From: Laura Gibbons
Sent: 01 October 2018 10:02
To: Planning.Responses
Cc: Anita Gardner
Subject: RE: Planning Consultation on: R/204/18/PL

Engineers Comments Regarding Surface Water Drainage

APPLICATION **R/204/18/PL**

Site Address: Springfield House Springfield Close Rustington BN16 2SZ

Drawing Title
**Surface Water
Drainage Layout**

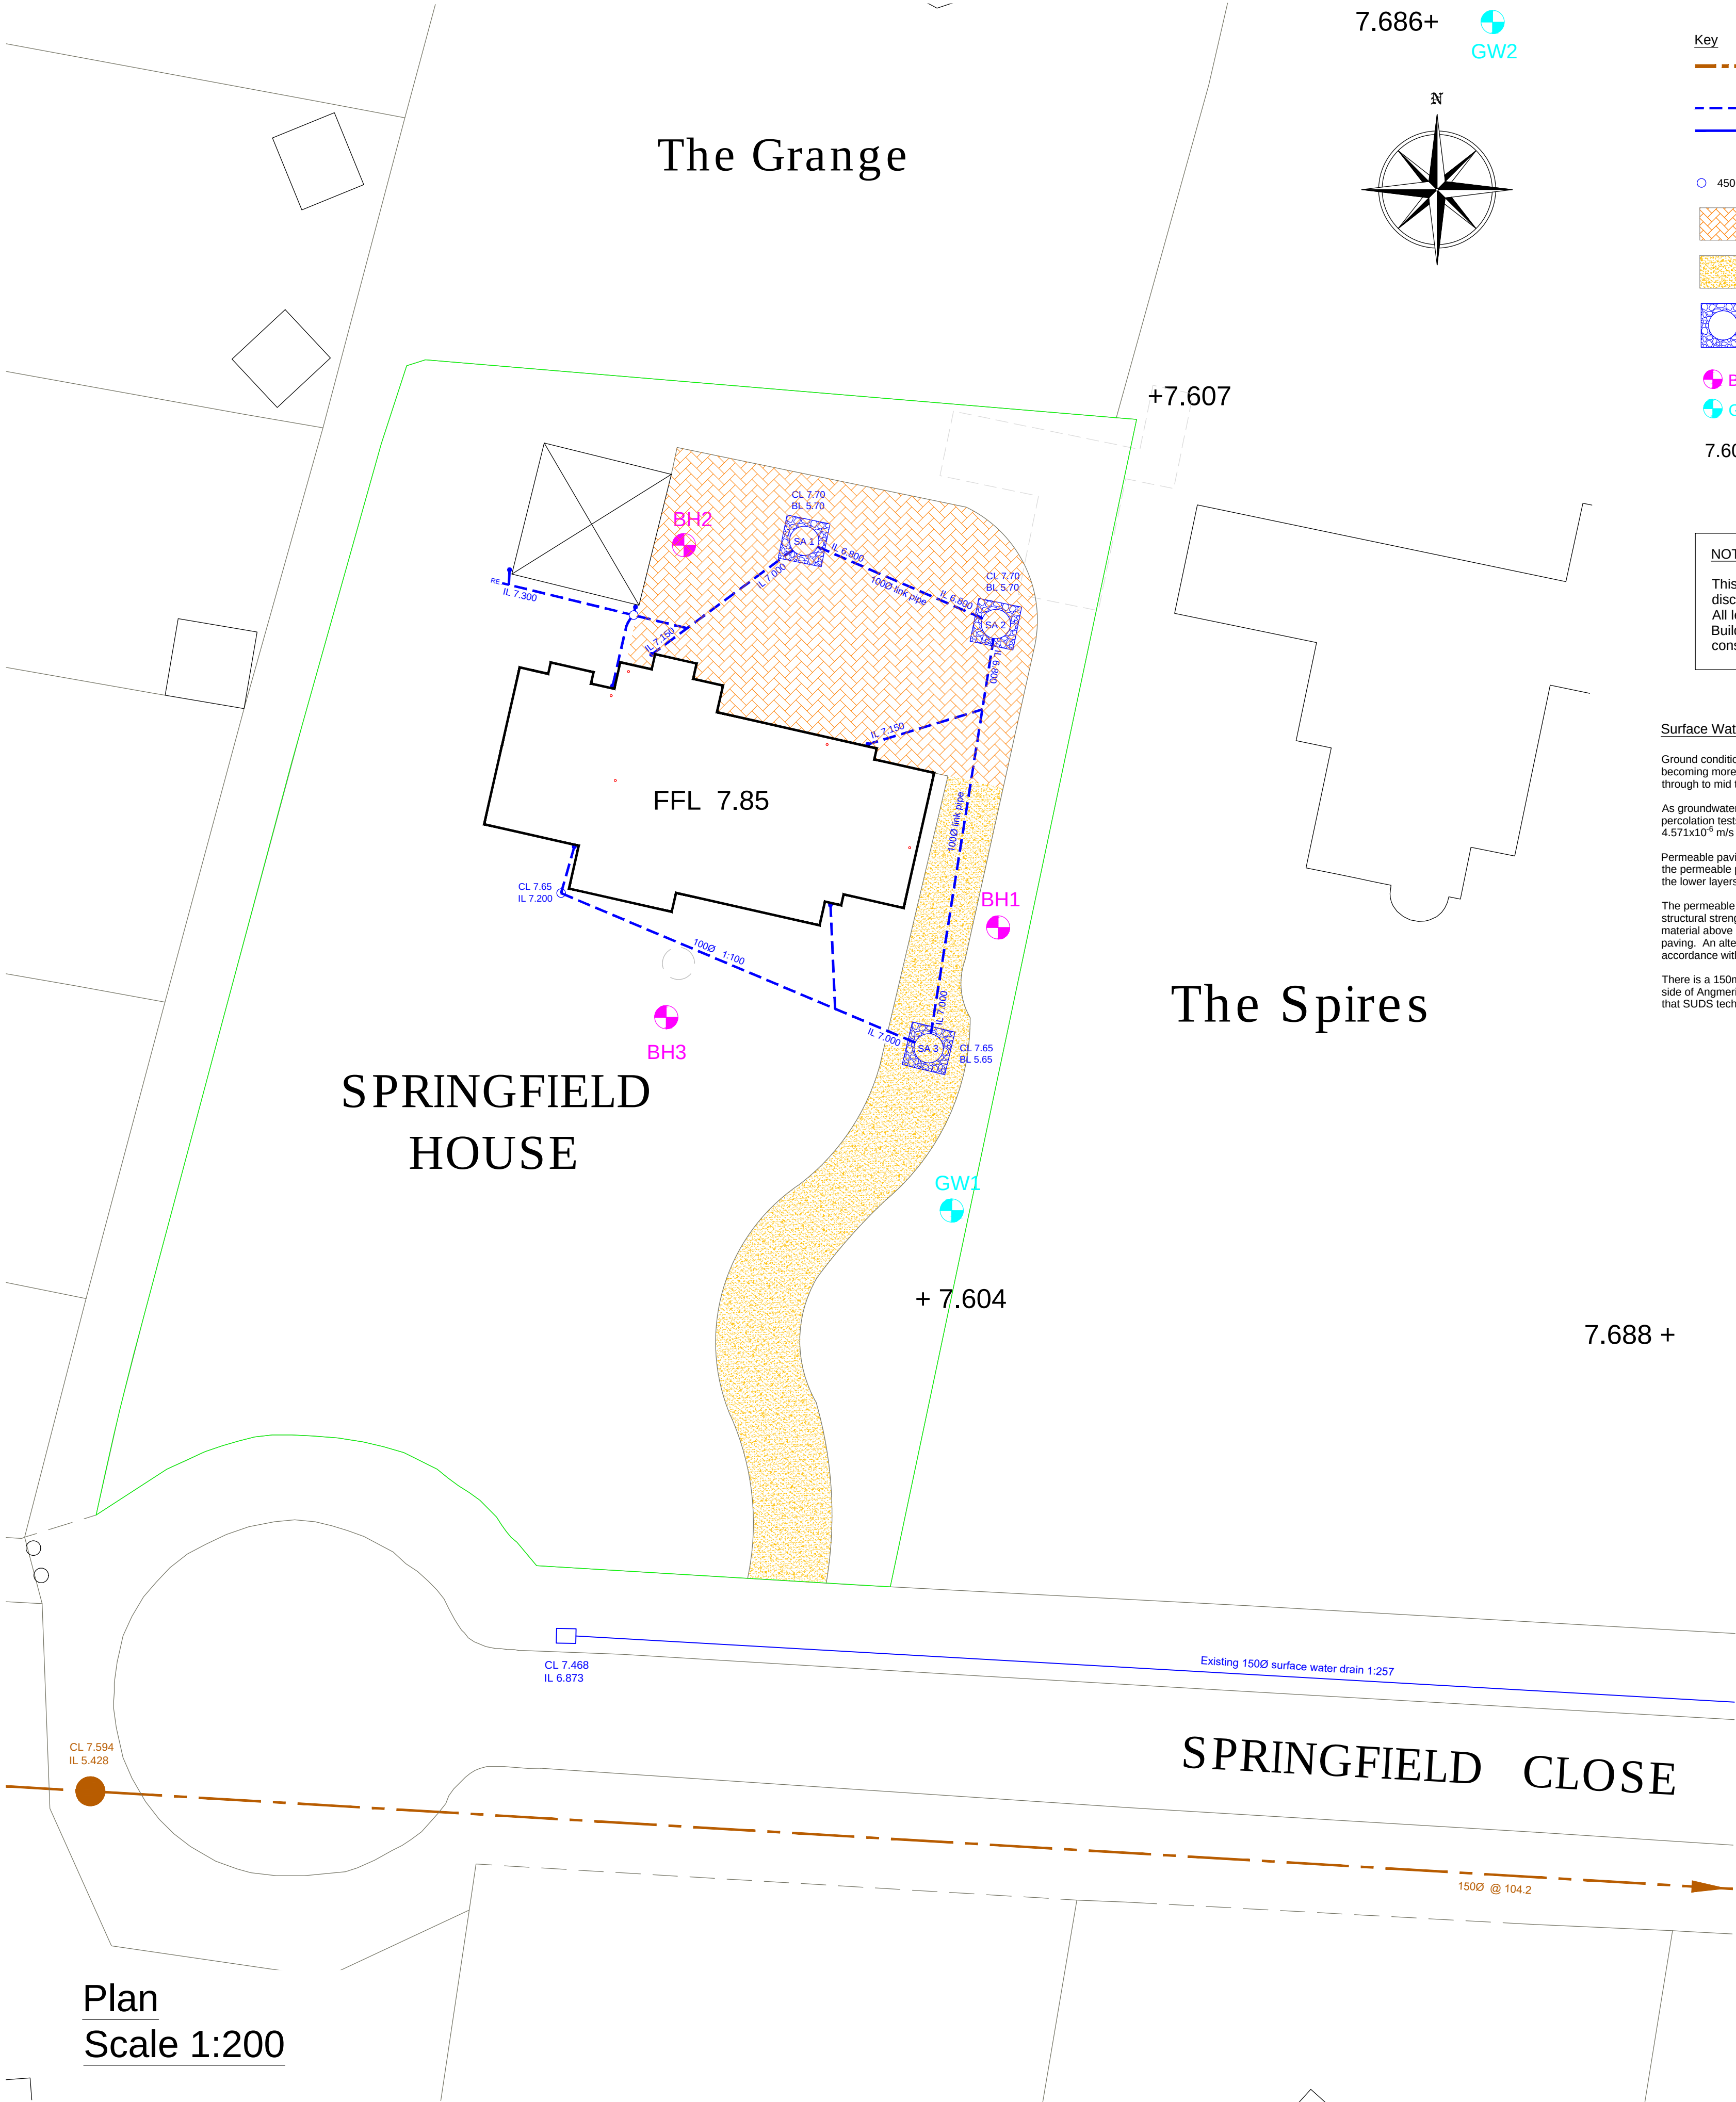
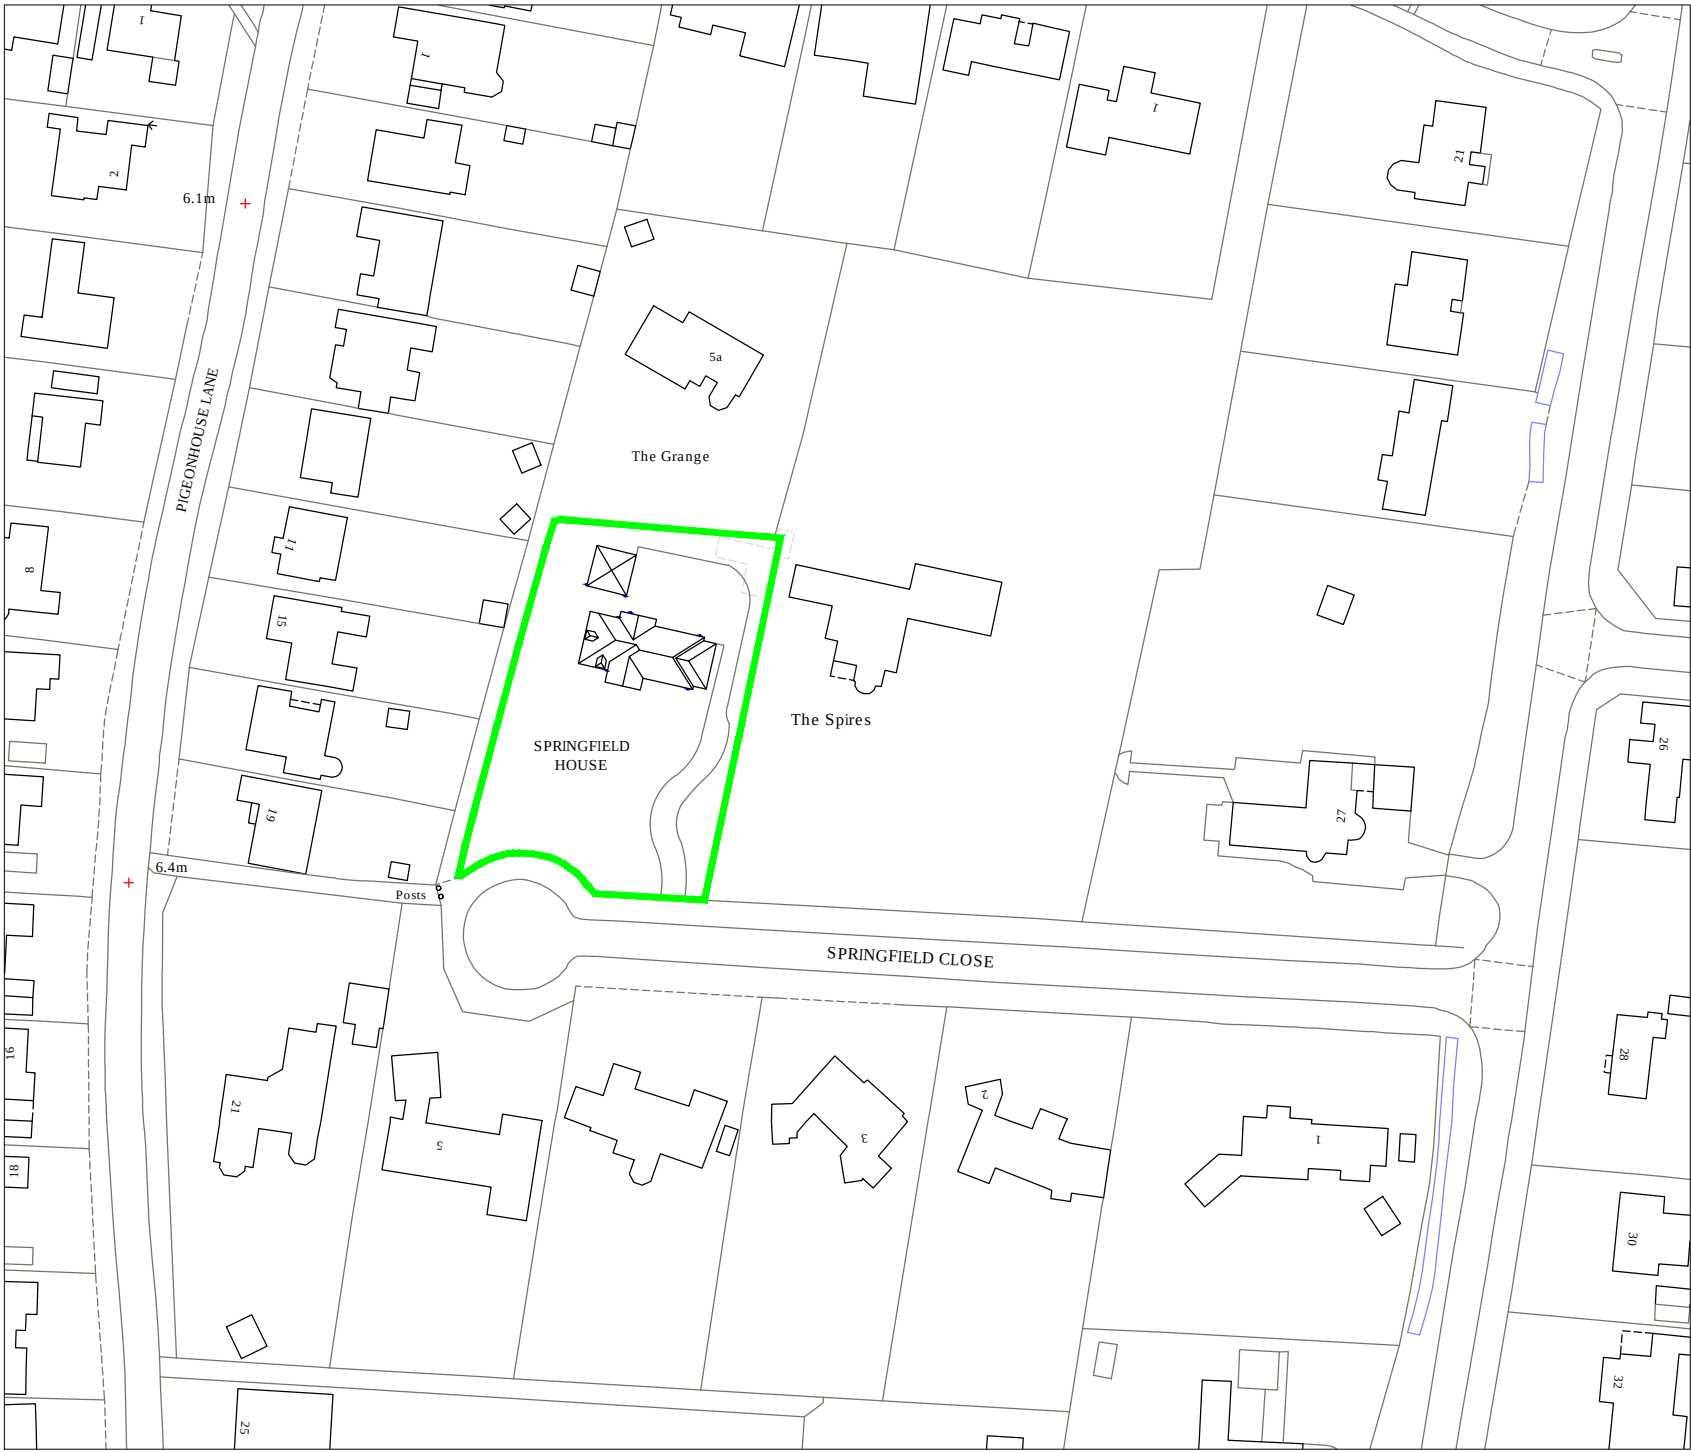
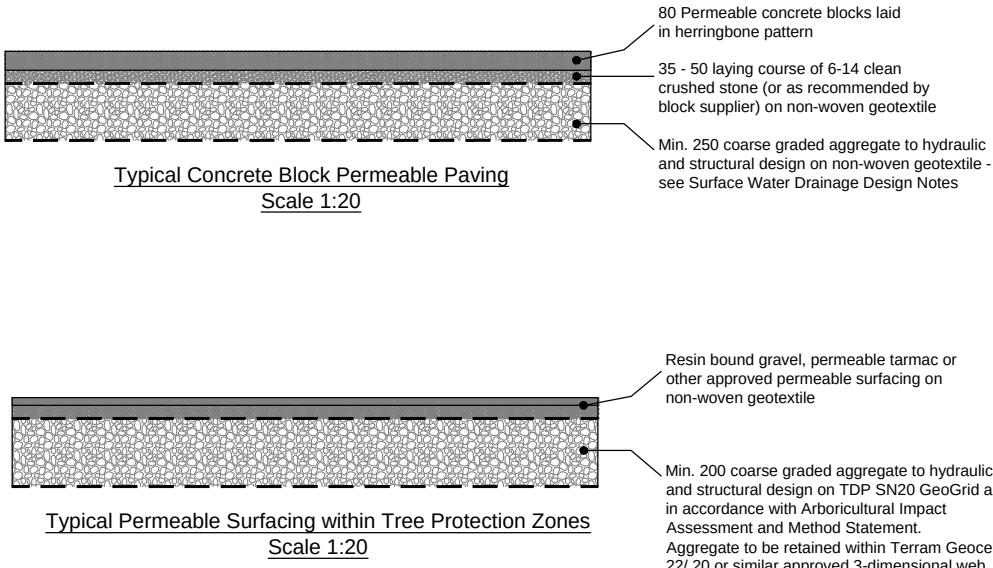
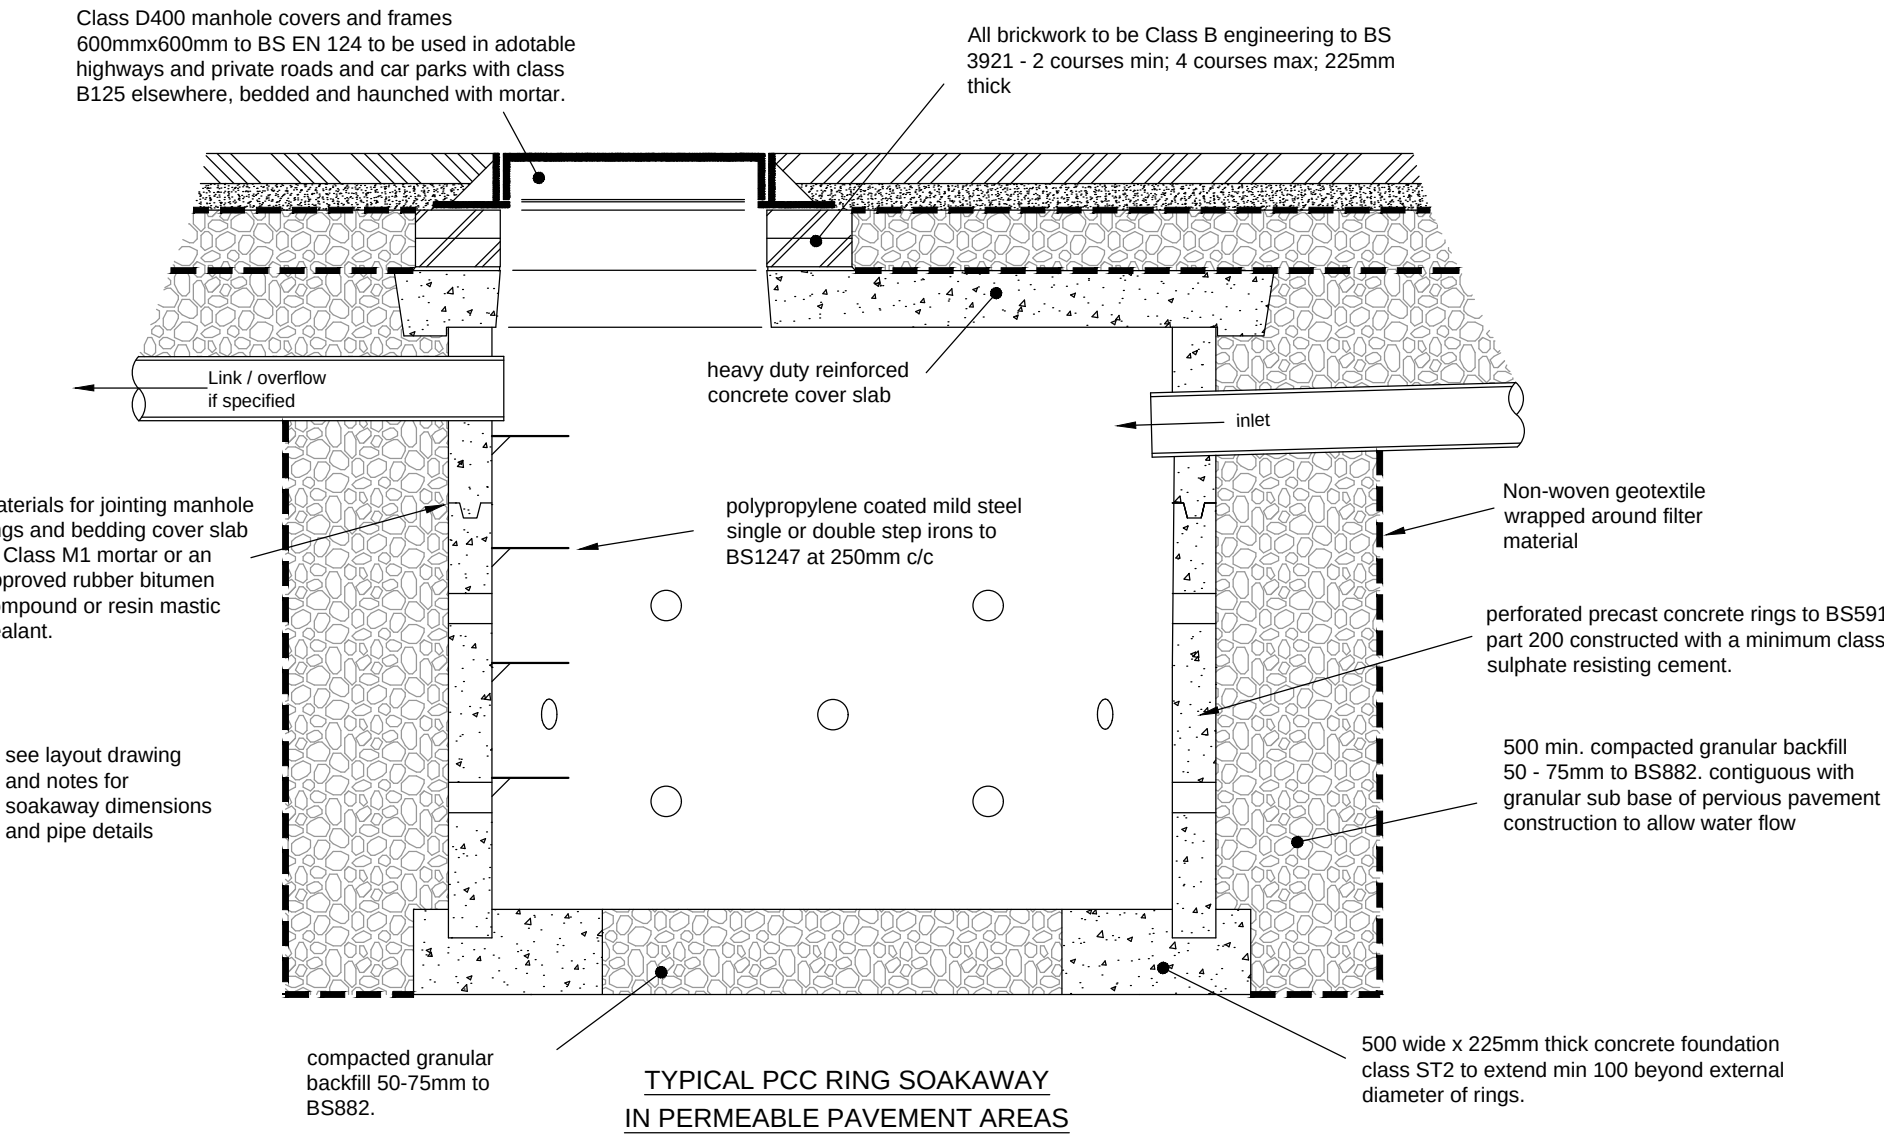
Soakaways must be investigated for surface water disposal.

Infiltration rates for soakage structures are to be based on percolation tests undertaken in the winter period and at the location and depth of the proposed structures. The percolation tests must be carried out in accordance with BRE 365, CIRIA R156 or a similar approved method and cater for the 1 in 10 year storm between the invert of the entry pipe to the soakaway, and the base of the structure. It must also have provision to ensure that there is capacity in the system to contain below ground level the 1 in 100 year event plus 40% on stored volumes, as an allowance for climate change. Adequate freeboard must be provided between the base of the soakaway structure and the highest recorded annual groundwater level identified in that location.

Any SuDS or soakaway design must include adequate groundwater monitoring data to determine the highest winter groundwater table in support of the design. The applicant is advised to discuss the extent of groundwater monitoring with the Council's Engineers. Supplementary guidance notes are also enclosed for information.
